Rezoning Transportation Analysis

Petition Number: 2022-205

Revision Log:

Date	Description
4-27-23	First Review (TM)
5-24-23	Second Review (DR)
6-13-23	Third Review (DR)
07-26-23	Fourth Review (TM)

Rezoning Plan
Petition # 2022-205

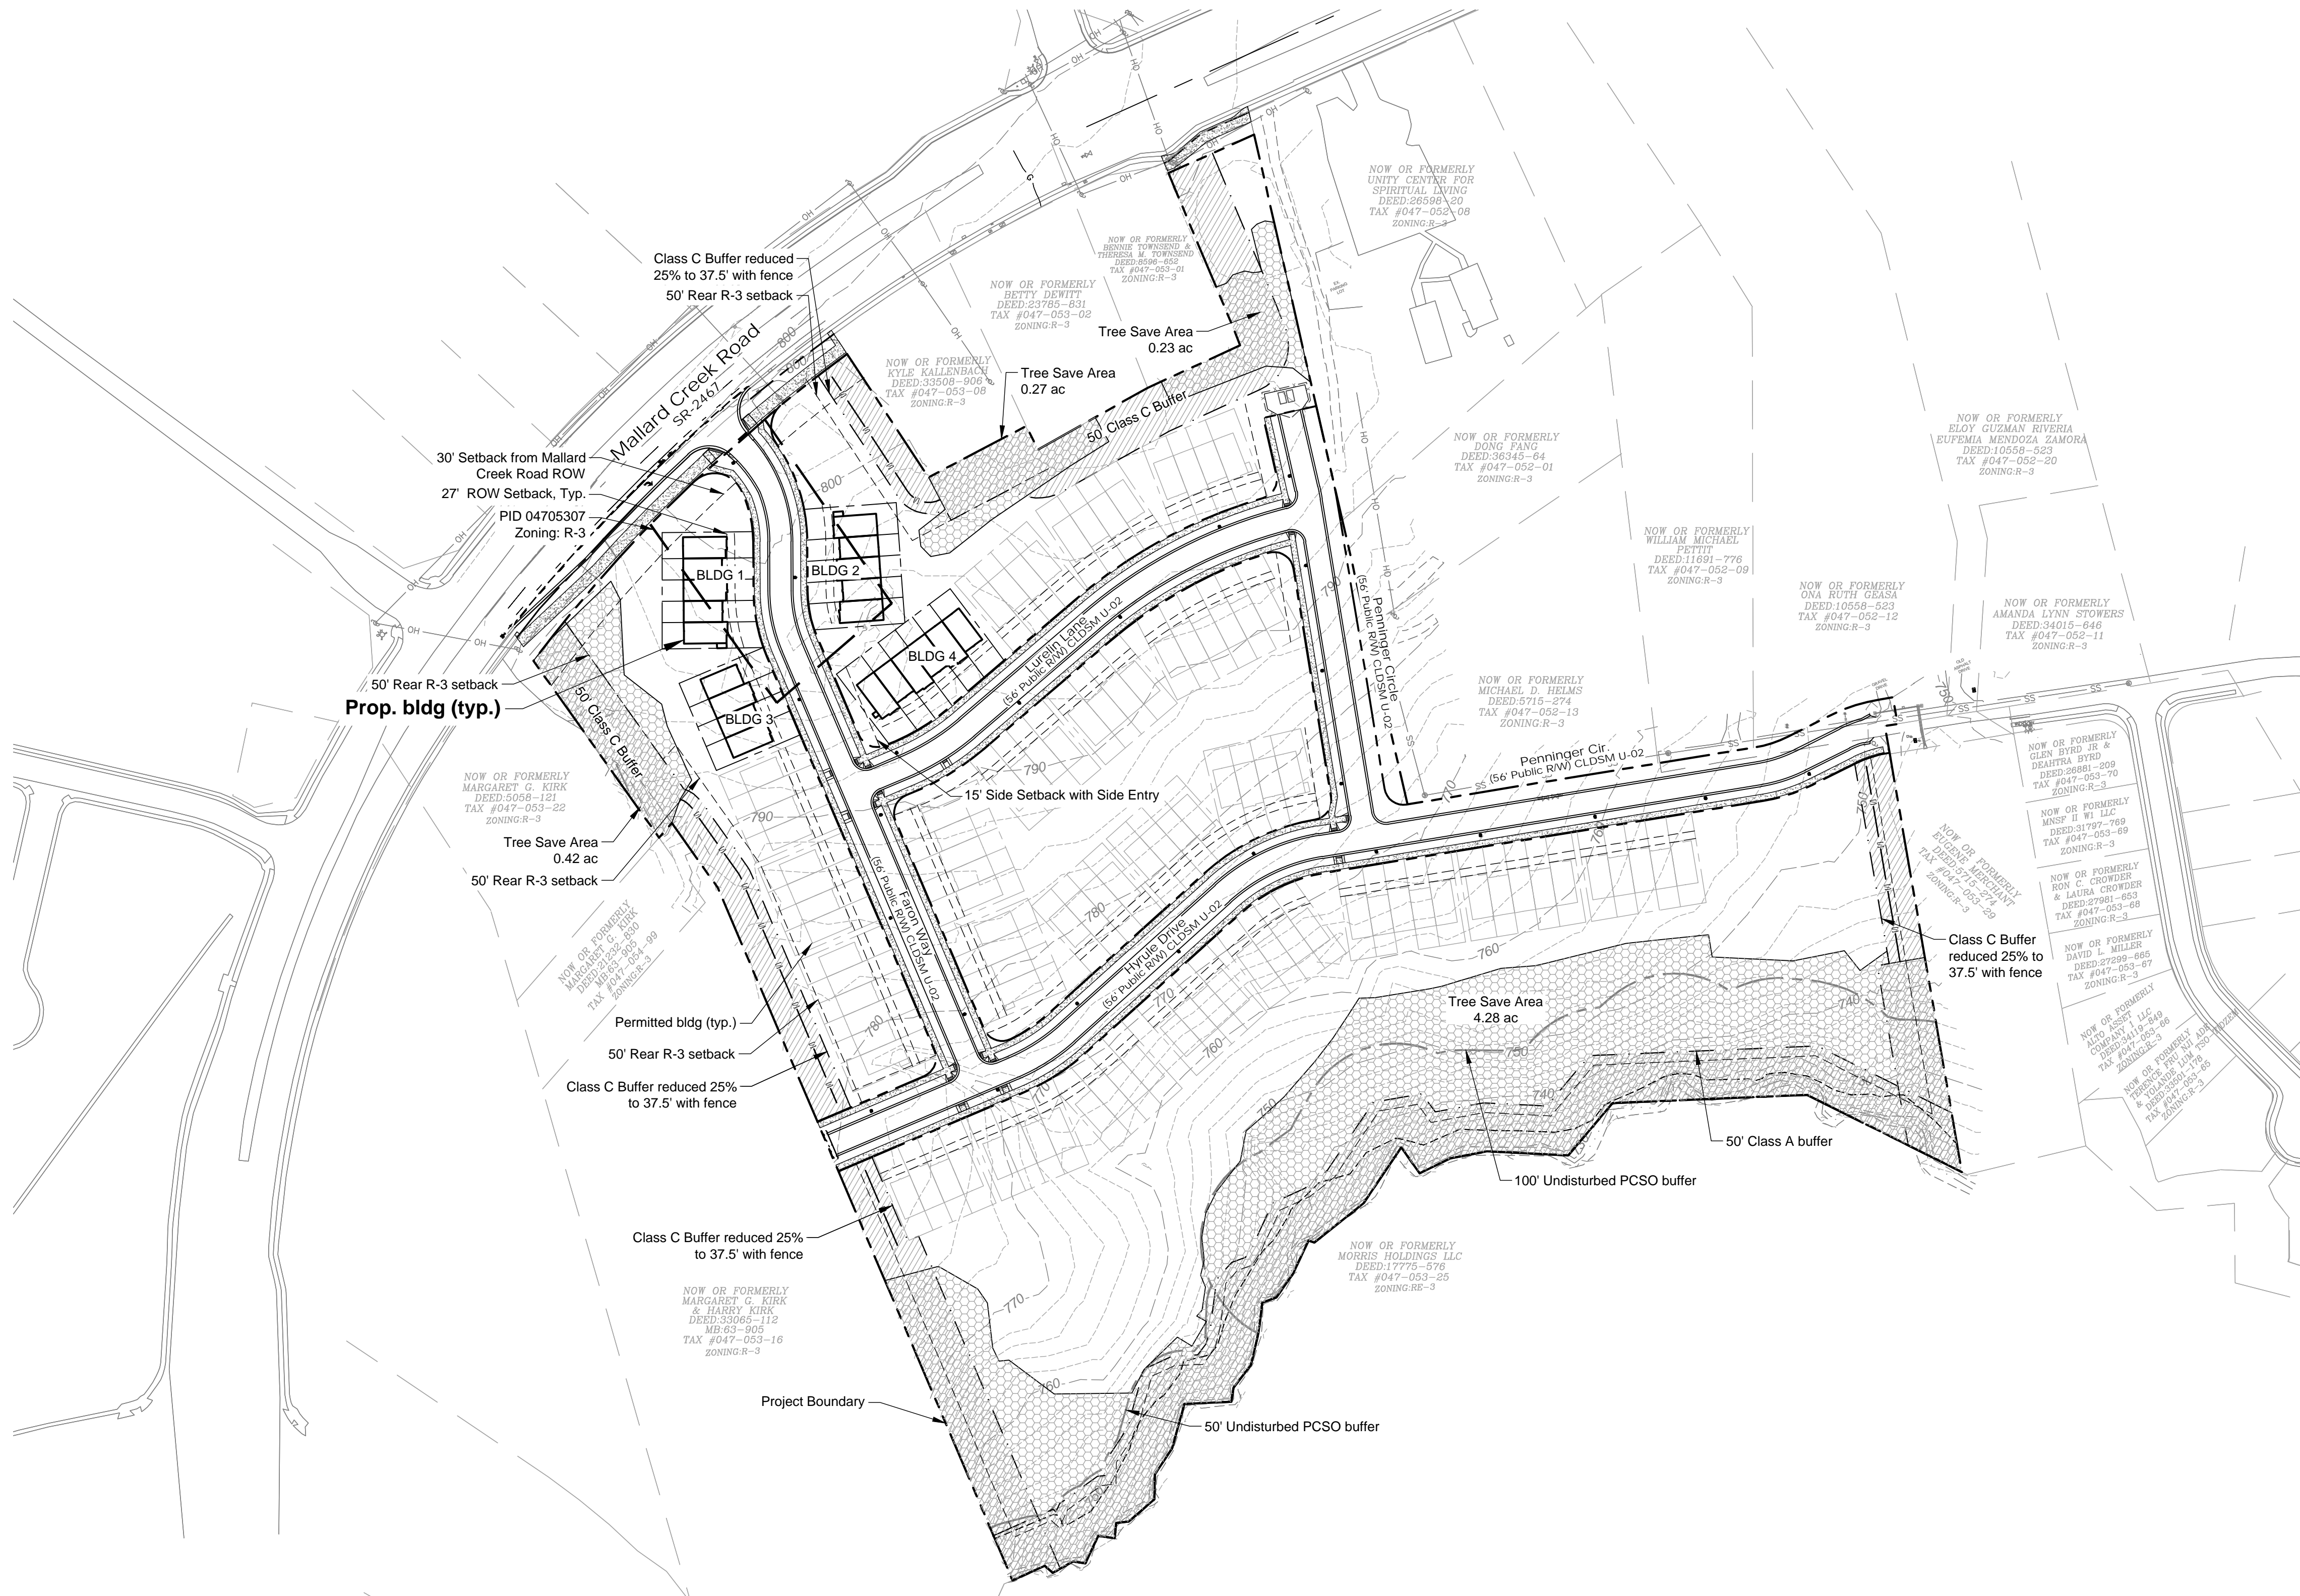
- a. ~~Mallard Creek Road:~~ Location of curb and gutter to be moved to 33 feet from roadway centerline to accommodate the Charlotte Streets Map with a roadway typical section of 4+ Boulevard, Shared Use Path.

~~Outstanding Comment from 04-27-23:~~ Label and dimension the curb and gutter from the centerline for each road on the site plan.

3. ~~Outstanding Comment from 04-27-23:~~ Revise site plan and conditional note(s) to commit to dedicate 50 feet of right of way from the road centerline. The site plan shall label and dimension the right of way from the road centerline.
